Lr.No. **D. Dis. A1/11822/89** dated **11.8.89.**

Sub: MMDA - Planning permission - for
**Residential Additional to the existing
building Door No.65, Spur Tank Road,
S.No.407/4, Block No.25 of Egmore Village**
Ref: **Approved - Regarding.**
1. Your Lr.*N5*WDC.D6/PPA/4103/89. Dt.26.6.89.

PROPOSED Planning Permission
 for fast food restaurant at
 Pte. No. 65 SPUR TANK ROAD, R.S. NO.
 407/4, Block No. 25 of Edmore. Ch. 83
 Madras. vide sanctioned B.A. 103/87
 dt. 21.8.87. scale 1cm:1m.

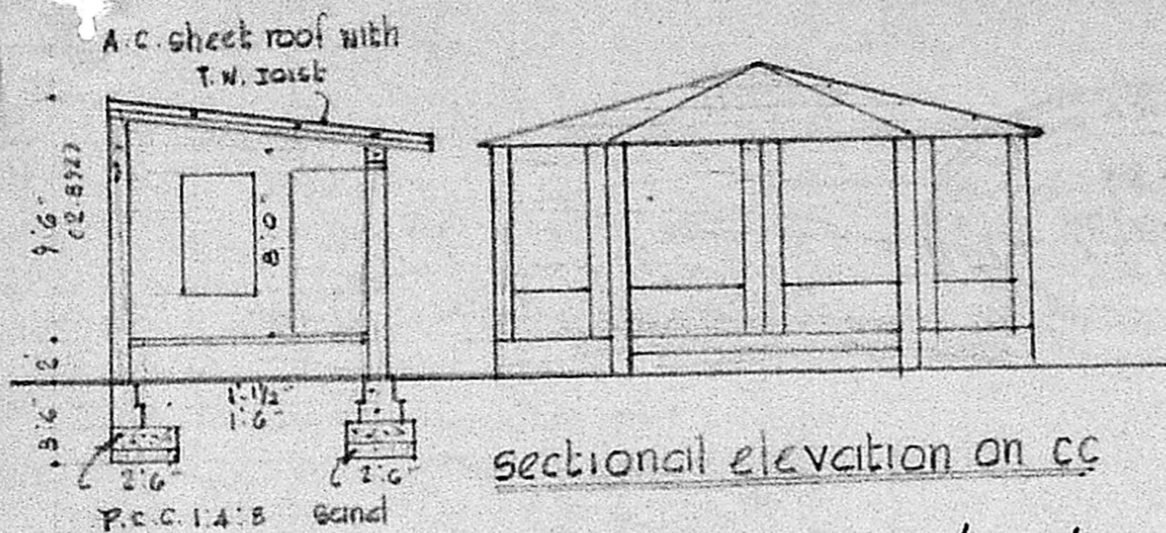
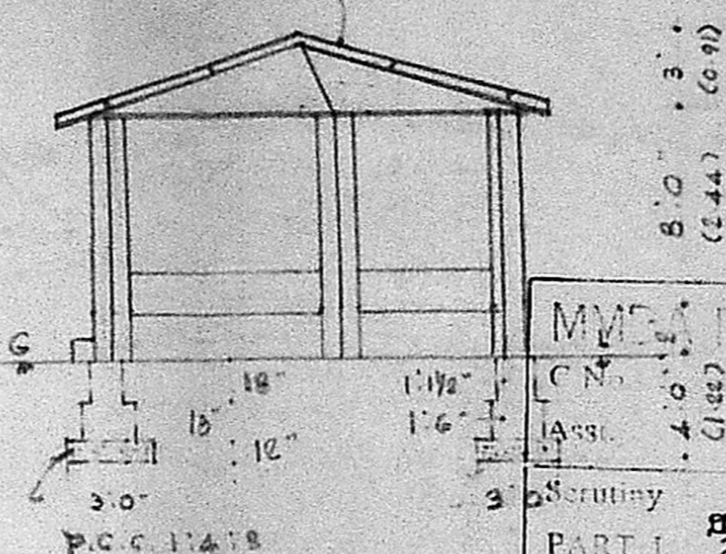
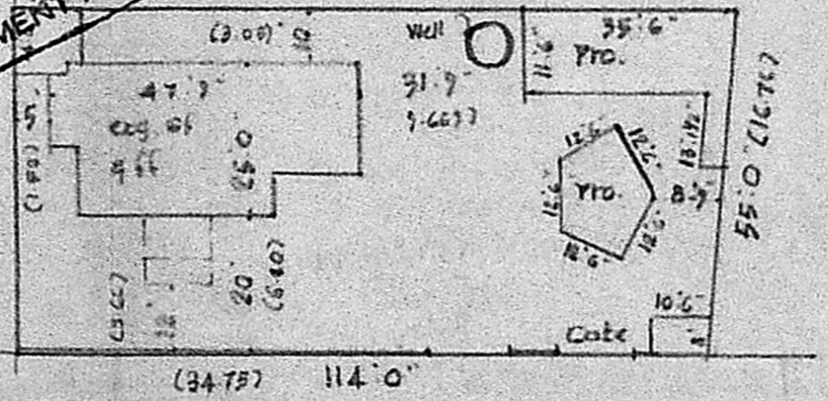
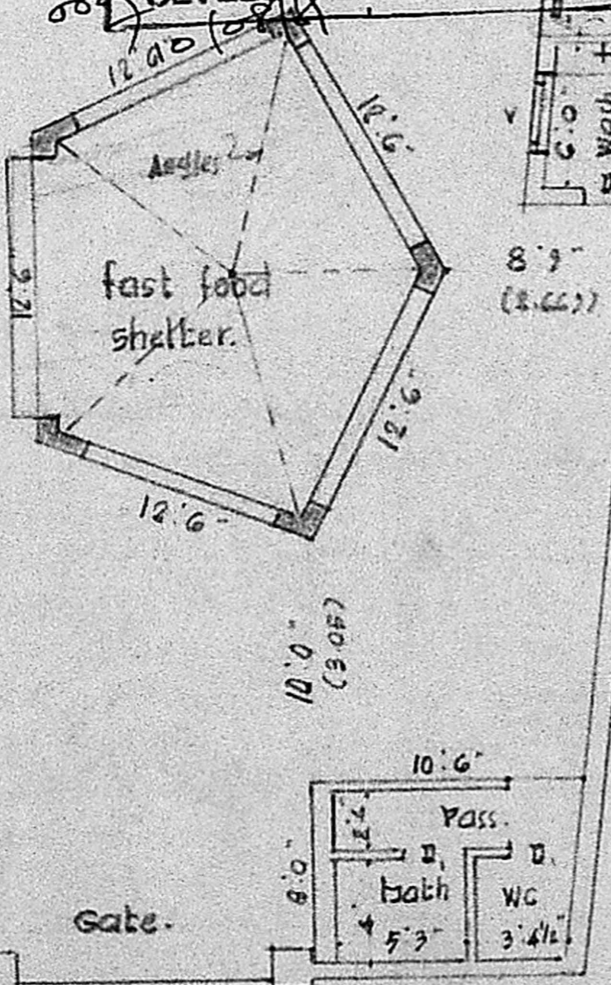
**iv. Bath and V.C. should be demolished before issuing
Building Permission.**
